Recommendation Report for Planning Permission for Works or Extension to a Dwelling

REF NO: BN/2/25/HH

LOCATION: 142 Barnham Road  
Eastergate  
PO22 0EH

PROPOSAL: Detached garage.

C			
B			
A			
Client	Mr & Mrs Buschhaus		
Address	142 Barnham Road : Eastergate		
Drawing	PROPOSED GARAGE	No.	2924:10
Scale	1:50 1:100 1:500 1:1250	Drawn	IS
		Date	Jan 25

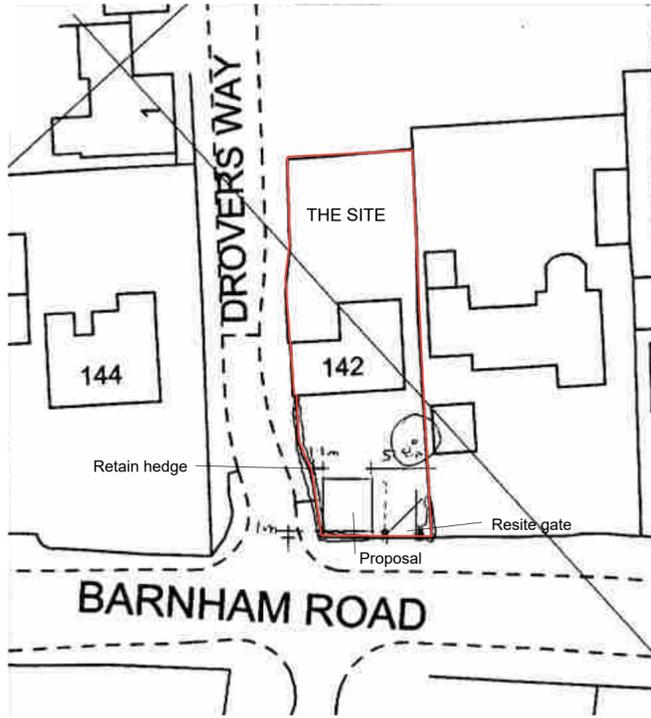
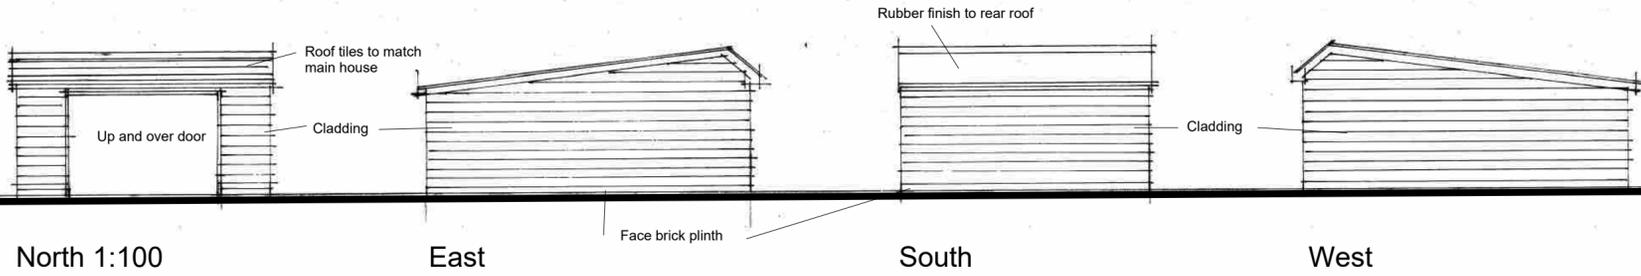
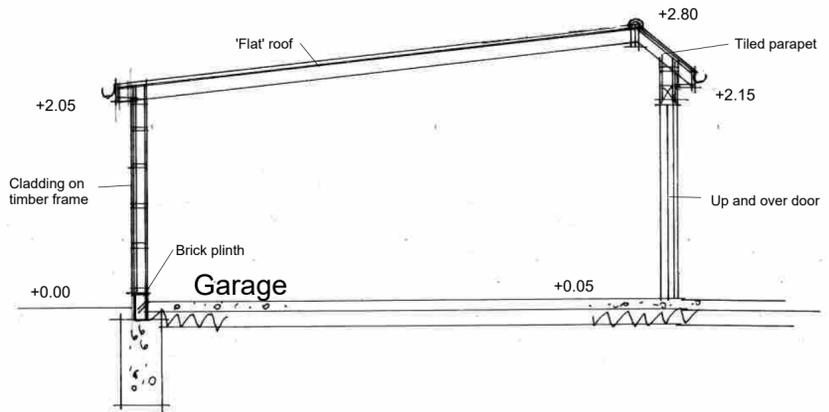
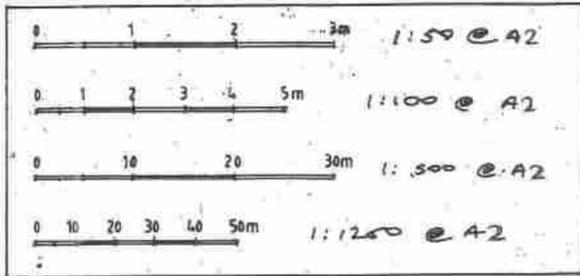
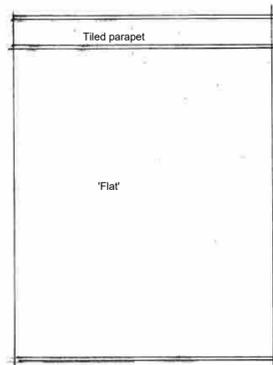
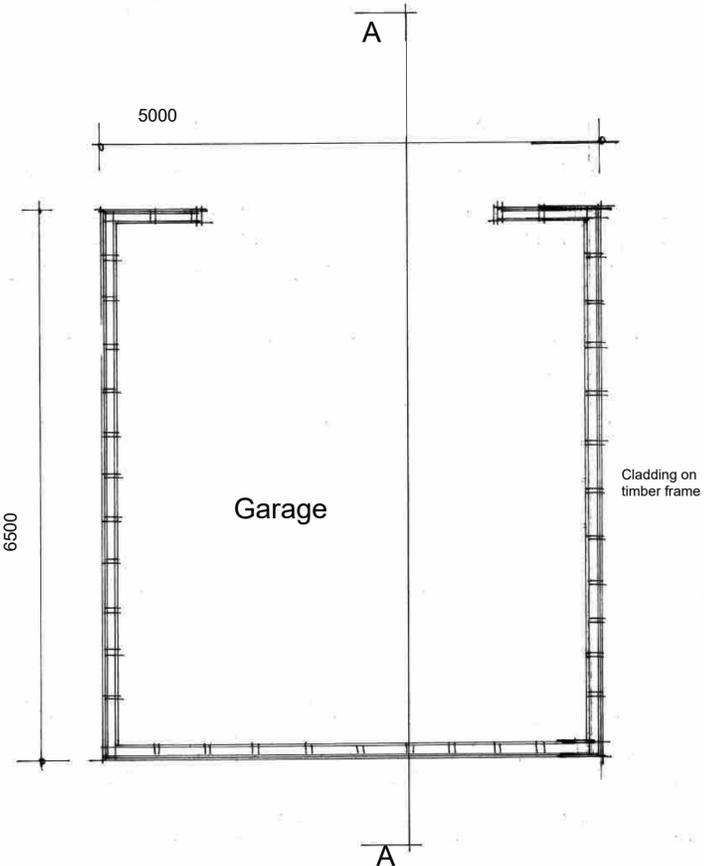
This application seeks a single storey detached garage within the front amenity of the site. 142 Barnham Road is located at the corner of Barnham Road and Drovers Way. The proposed garage would be highly visible from the street scene, located to the front western corner of the application site. The dwelling is located in an area of character that features large Edwardian style dwellings.

The detached single storey garage would be set in a maximum of 1.1m from the front and western side boundaries, although parts of the garage would be constructed very close to the boundaries, given the irregular shape of the plot to the front. The garage would measure 6.5m in depth by 5m in width by approx. 2.8m in height. The materials used for the walls would be timber cladding on a brick plinth base. The garage door to the north elevation would be a metal door. The garage would feature a tiled roof to match the existing dwelling with rubber finish to the flat portion of the rear roof. Whilst the materials proposed for the garage are acceptable, the siting and scale of the garage would not be in keeping with the character of the host dwelling, street scene or wider area.

The proposed garage, by reason of its siting and scale, would appear unduly prominent within the street scene of Barnham Road. The proposed development would be a visually obtrusive form of development and would result in demonstrable harm to the character of the locality and visual amenity of the host dwelling, street scene and wider area. The proposed development is therefore contrary to policies D DM1 and D DM4 of the Arun Local Plan, Part M of the Arun Design Guide, and policies ES5 and ES7 of the Barnham and Eastergate Neighbourhood Development Plan.

The proposed development would be located to the front of the site and would be visible from the street scene (Barnham Road) and the Area of Character, constructed close to the front and western side boundaries. The siting and scale of the garage would be obtrusive in this location and would appear unduly out of place within the area of character, sited significantly forward of the established building line on a prominent corner plot. Therefore, the proposed development would result in harm to the character of the area of character and is unacceptable in this location. The works would be highly visible from the street scene resulting in unacceptable harm to the character to the Area of Character.

- 1 The proposed garage, by reason of its siting and scale, would appear unduly prominent within the street scene of Barnham Road. The proposed development would be a visually obtrusive form of development and would result in demonstrable harm to the character of the locality and visual amenity of the host dwelling, street scene and wider area. The development would also result in unacceptable harm to the significance of the non-designated heritage asset. The proposed development is therefore contrary to policies D DM1, D DM4 and HER DM4 of the Arun Local Plan, policies ES5 and ES7 of the Barnham and Eastergate Neighbourhood Development Plan and the NPPF.
